PROJECT NO. PR-2019-002671

Application No. SI-2021-00255 and -00256

Memorandum

Re: DRB Comment Responses for PR-2019-002761 (SI-2021-00255 and SI-2021-00256)

**2 CLUBHOUSE- RIGHT ELEV**  
 SCALE: 1/8" = 1'-0"

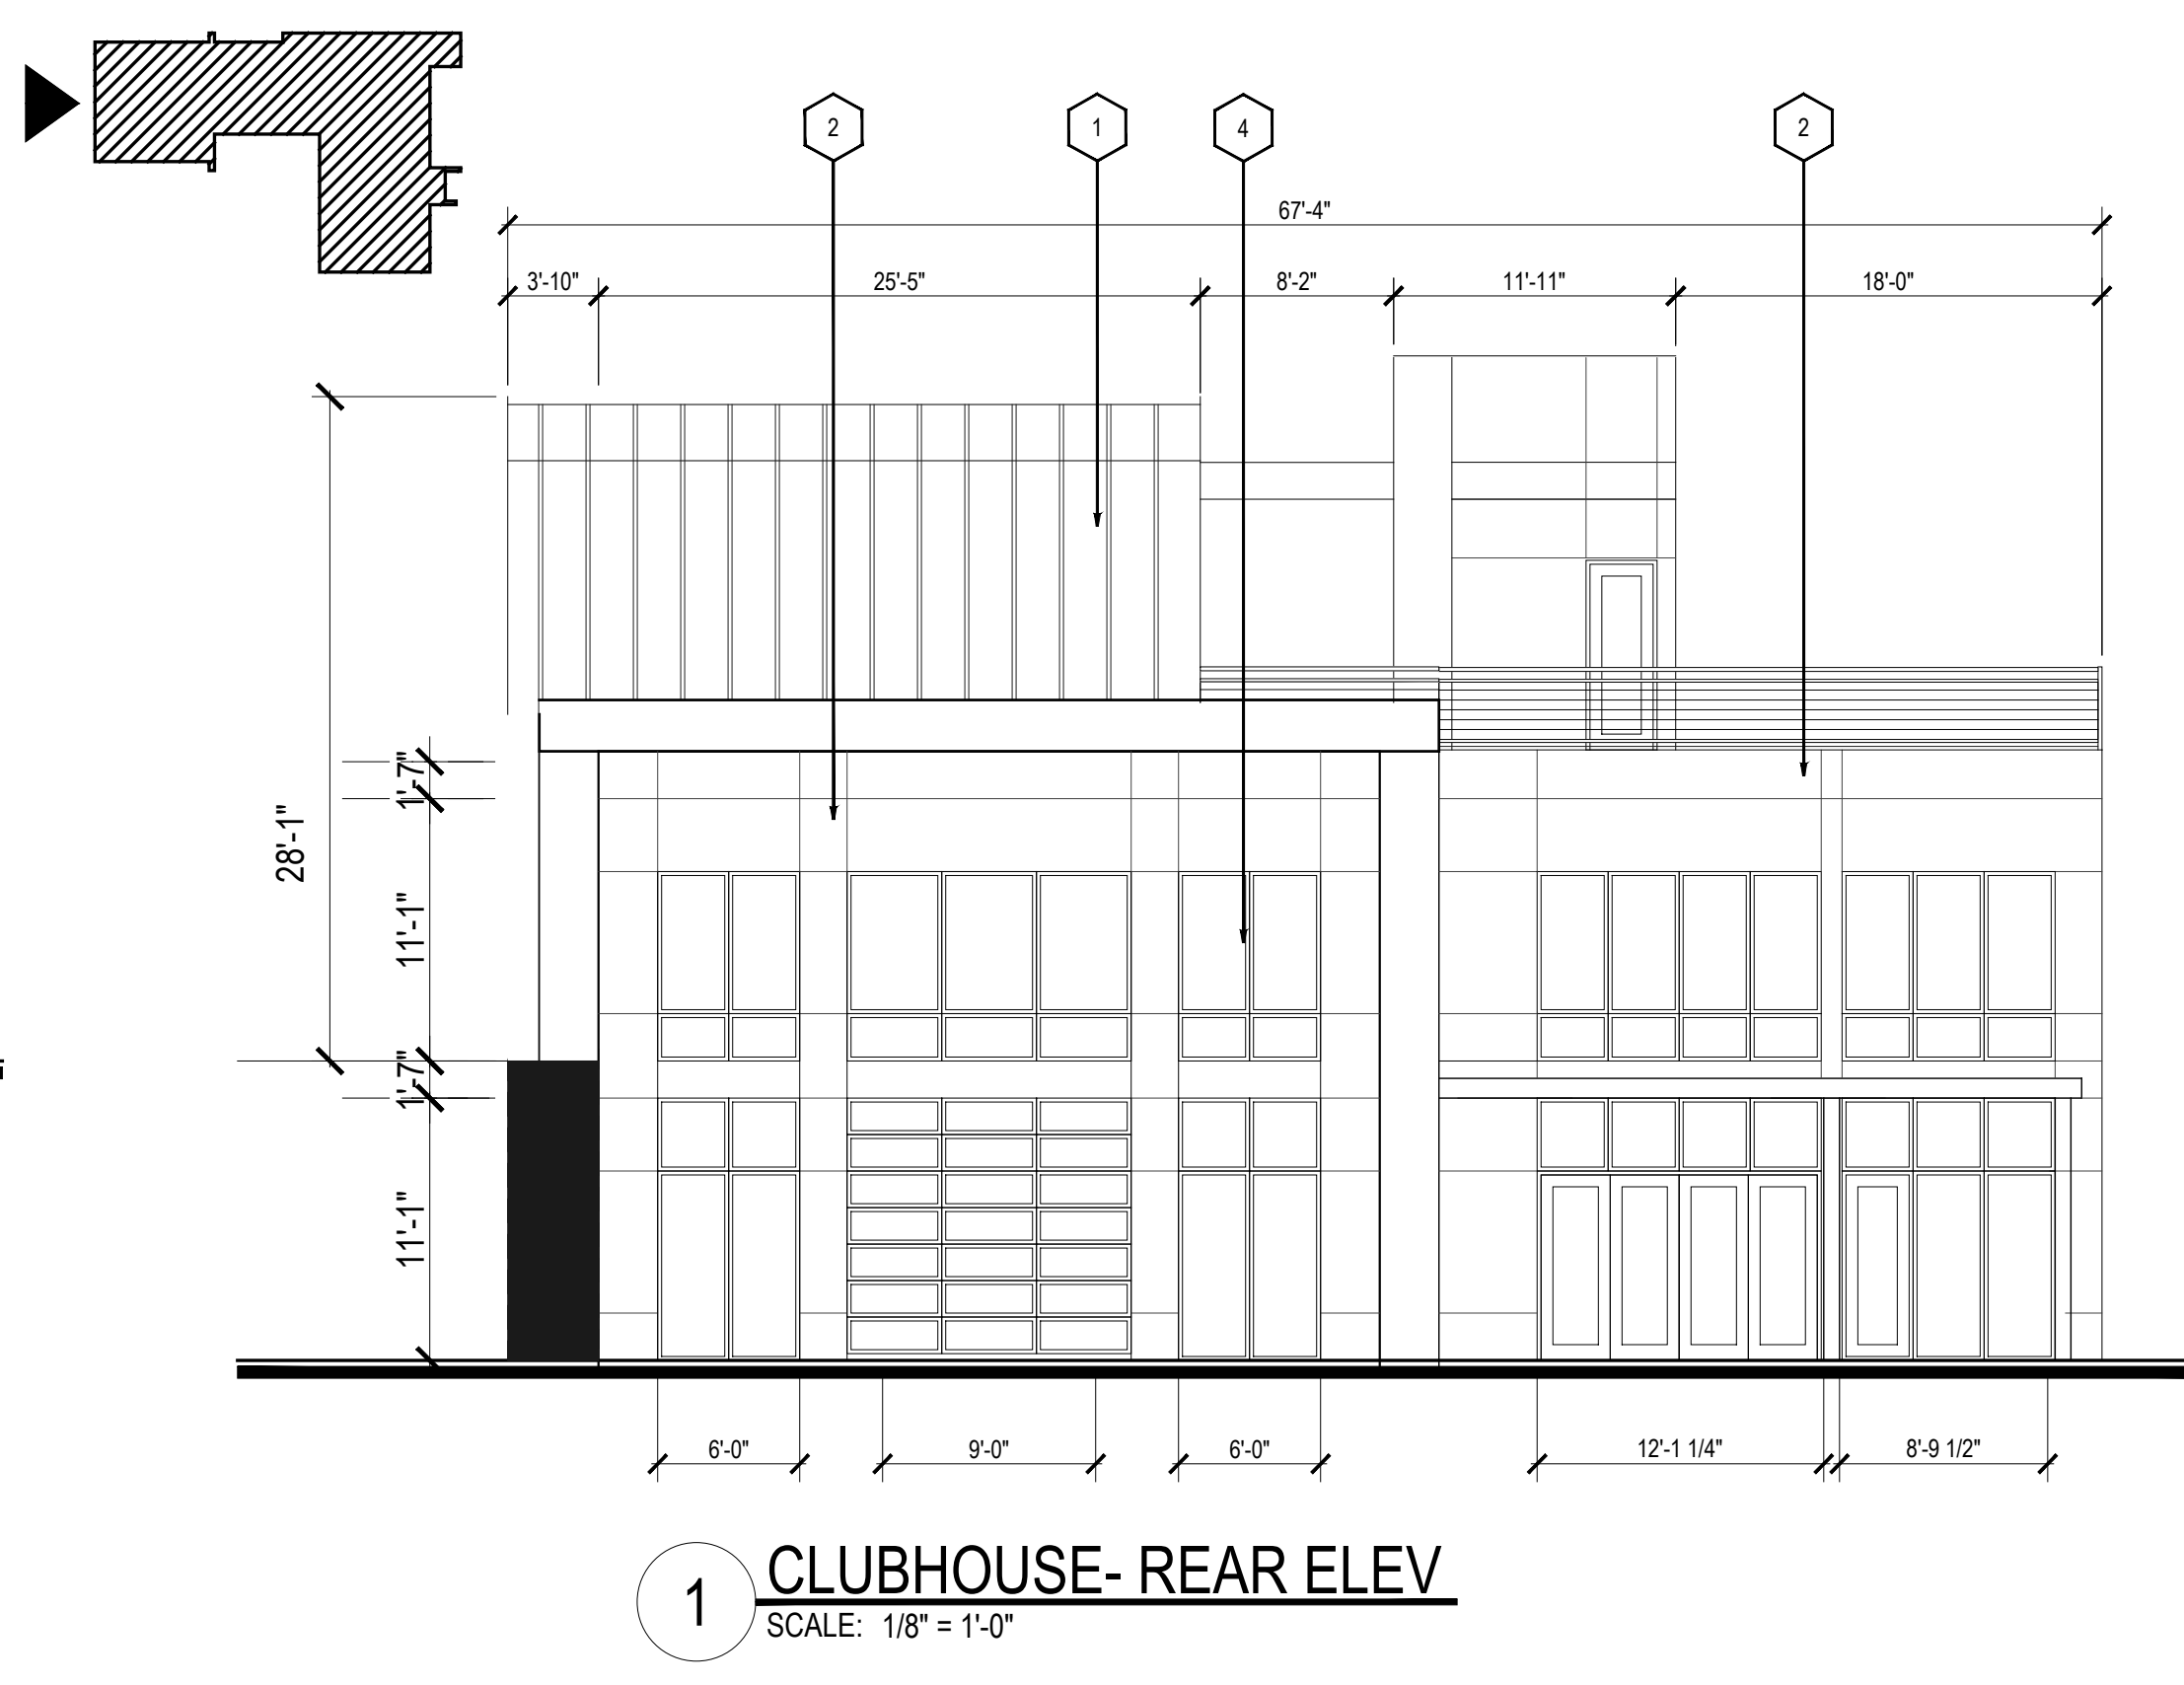
10. Specify how the Façade Design requirements of 5-11(E)(2)(a) are being met in a comment response letter and/or on the Site Plan.
 - a. 5-11(E)(2)(a) regulates building design for street-facing facades. The only facades within the proposed development that are street-facing are the north elevations of Building Type I (left) and the Clubhouse (right).***

The awnings, building overhangs, and horizontal trims around the clubhouse are respective of the human scale and visually indicate separation between ground and upper floor. The north side of the clubhouse building includes several large windows with an overhang on the right side and additional windows in the center of the elevation. An additional transom window with an awning has been added to the left side of the elevation to ensure that at least one required element is

provided at least every 40 feet along the façade. These windows and the awning cover at least 40 linear feet of a total façade length of 106 feet or approximately 38%. Because this façade is over 100 feet long, there are variations in the façade, including projections and recesses as well as multiple colors to break up the mass.
